**From:** [REDACTED]  
**To:** [Stallingborough CCGT](#)  
**Cc:** [REDACTED]; [REDACTED]; [REDACTED]  
**Subject:** RE: Your Ref EN010161-000013 - Stallingborough CCGT Scoping Opinion Comment - FAO Alison Down (Our Ref DM0164/24/DCO)  
**Date:** 18 March 2024 12:19:09

Many thanks for giving North East Lincolnshire Council (NELC) the opportunity to comment on the scoping opinion submitted and apologies for the delay in responding.

FIGURE NUMBER
 Figure 6E

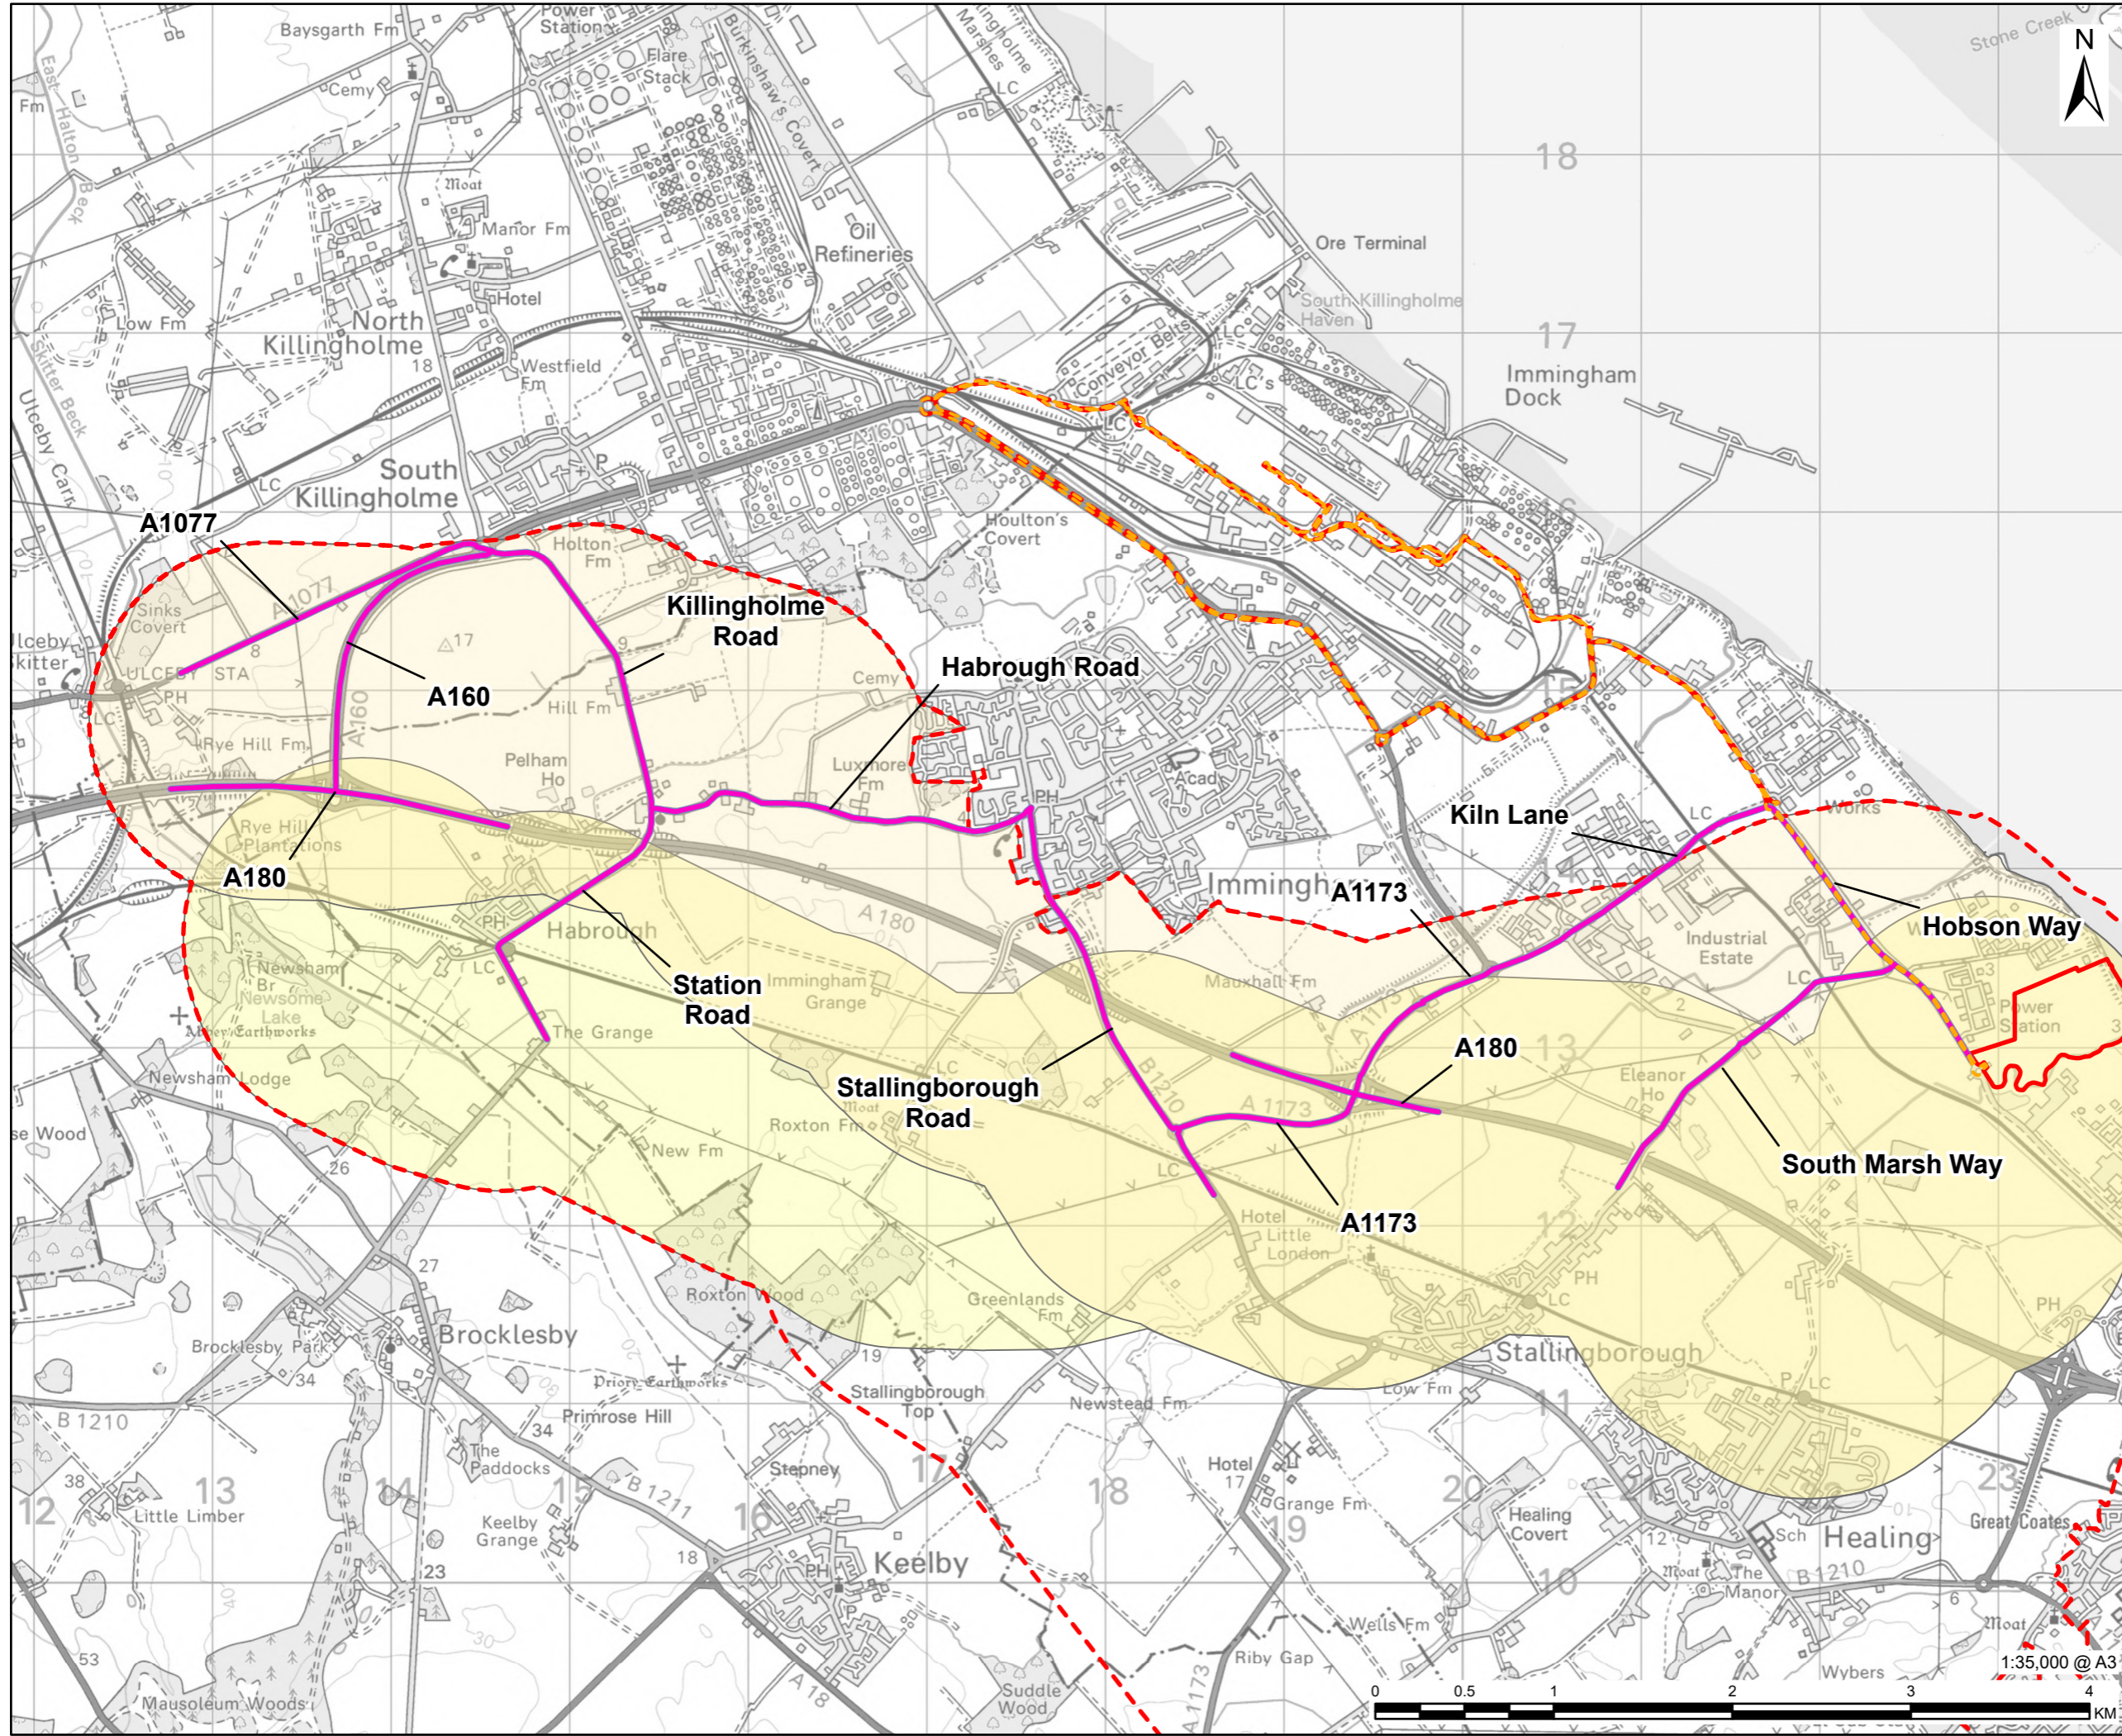
- 6.10.24-25 - Please note South Marsh Road to the west of Hobson Way is a Bridleway only and is not available to passing vehicular traffic.
- It is not clear if construction traffic is anticipated from the A180 to the off site lay down area via the Pyewipe and Westgate roundabouts? If they are ATC should be undertaken at these locations and accident data collected due to the congested nature of these roundabouts.

- Consideration should be given to impacts of HGV traffic on Kiln Lane rail level crossings and any other rail crossings (bridges or level crossing) in terms of suitability, impacts and safety. Early consultation with Network Rail is strongly advised.

FIGURE NUMBER
Figure 61

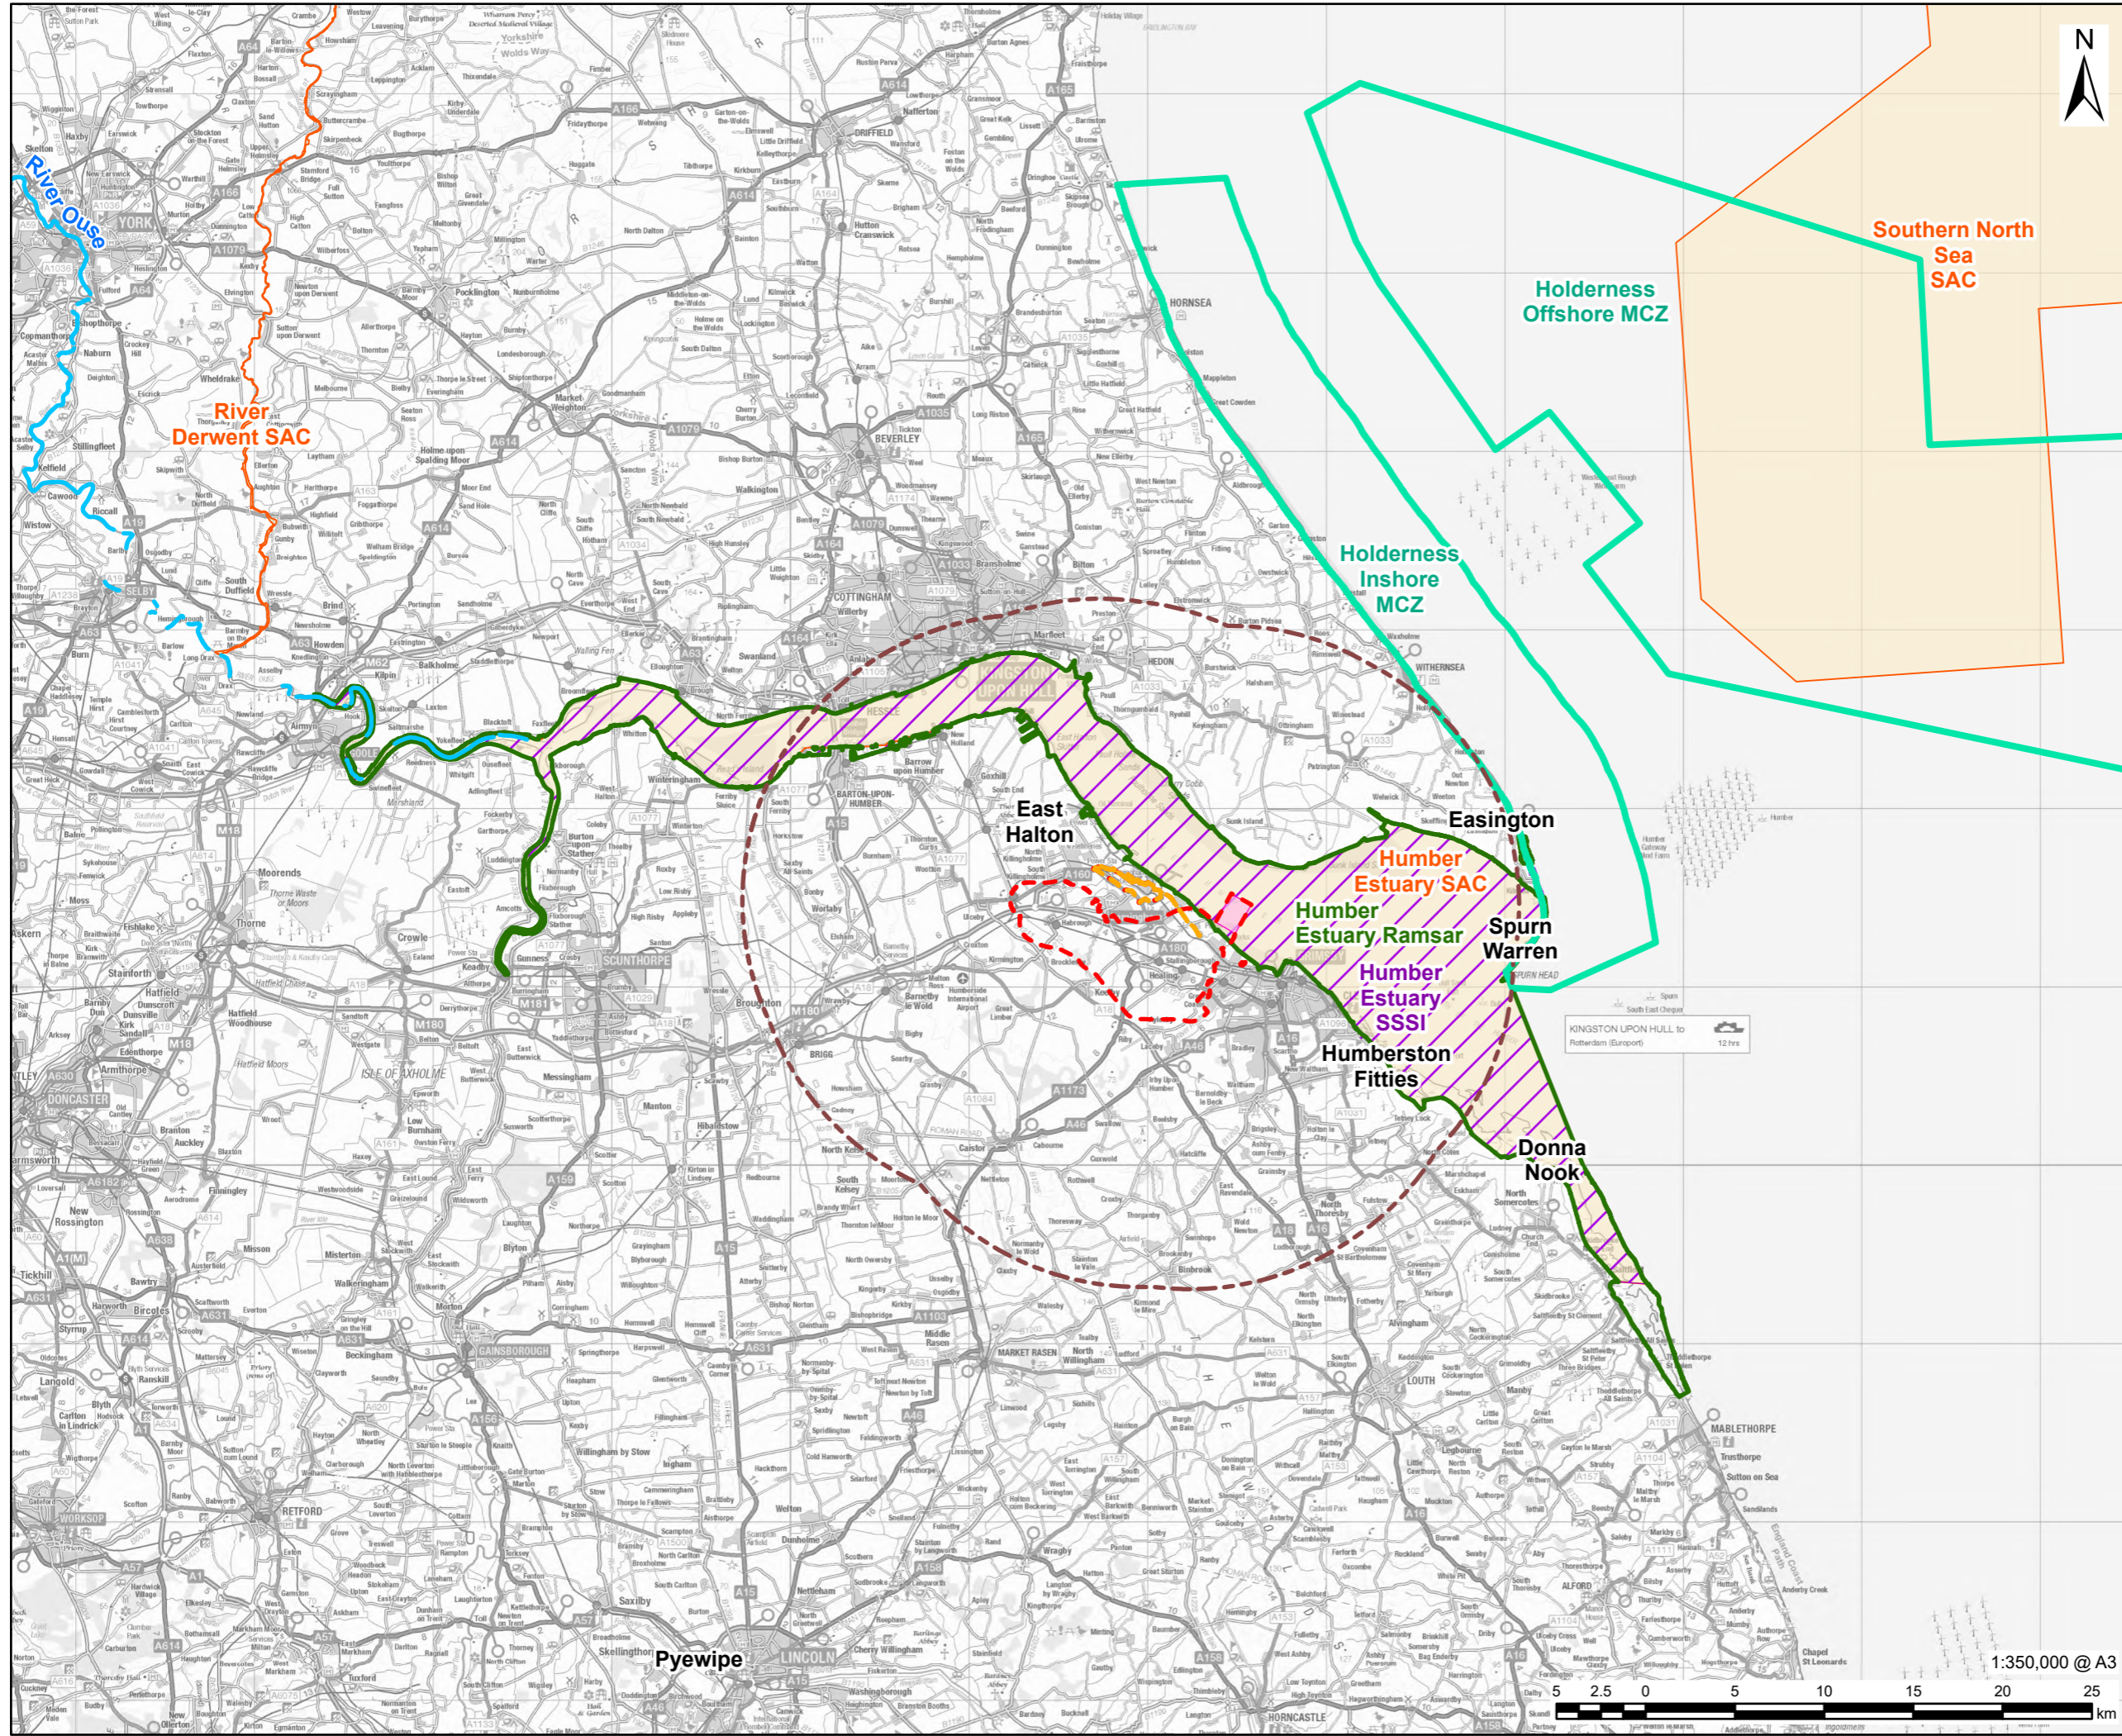
- It is not wholly clear why noise impacts on residential properties are being screened out from specific assessment due to their temporary nature relying only on the CTMP limitations.
